Submission by Mallard Pass Action Group (MPAG)

Deadline 7:

ISH4

Written Summary of Oral Case

Plate 9: Establishing Grass Mix Under PV Drip Line³¹³²

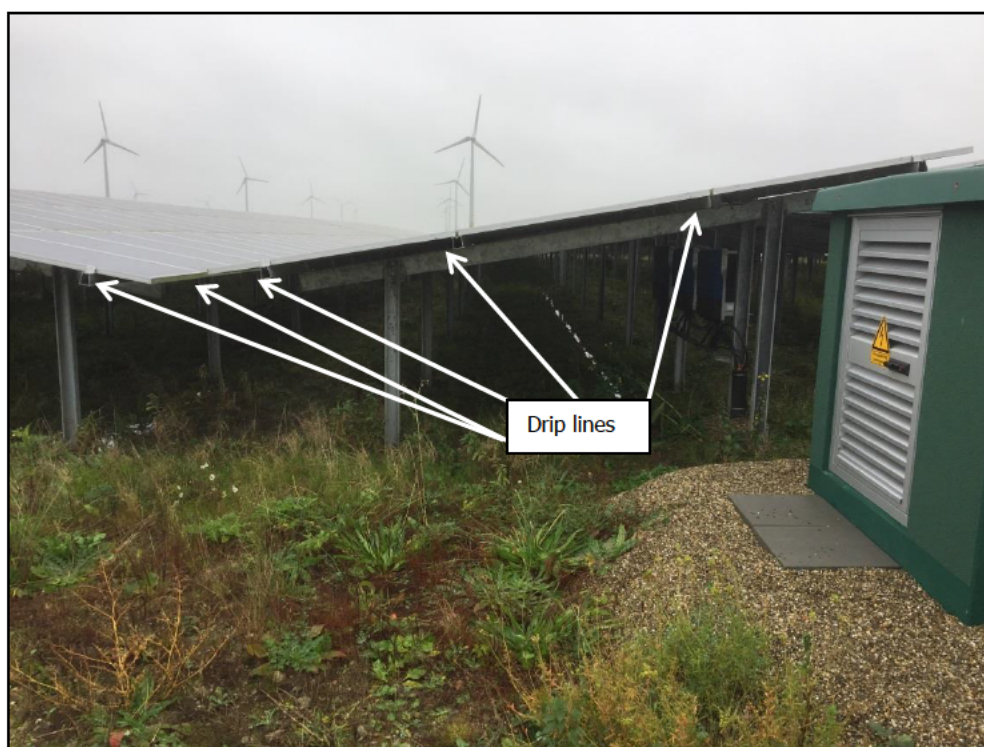
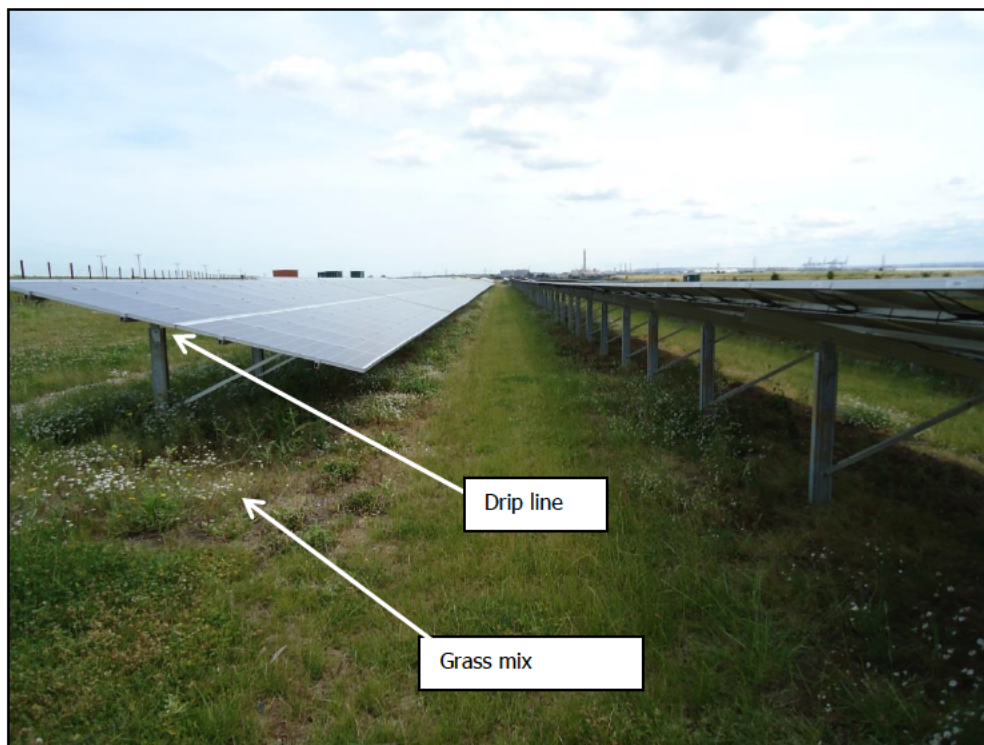
5.0.2 **Grass establishment**. The seed mix identified for the grassland is said to be **slow growing**, shade tolerant species and they need considerable time to establish properly to increase infiltration rates and reduce risk of surface water flood risk. It will also help with enhancing resilience of the soil to resist compaction and trafficking. MPAG would like to see **12-18 months before construction**, harvest the crop, drill the grass, and manage it appropriately through the first year so a full root system can be established. That will accrue the necessary benefits to start construction and have a more robust baseline for the next 60 years.
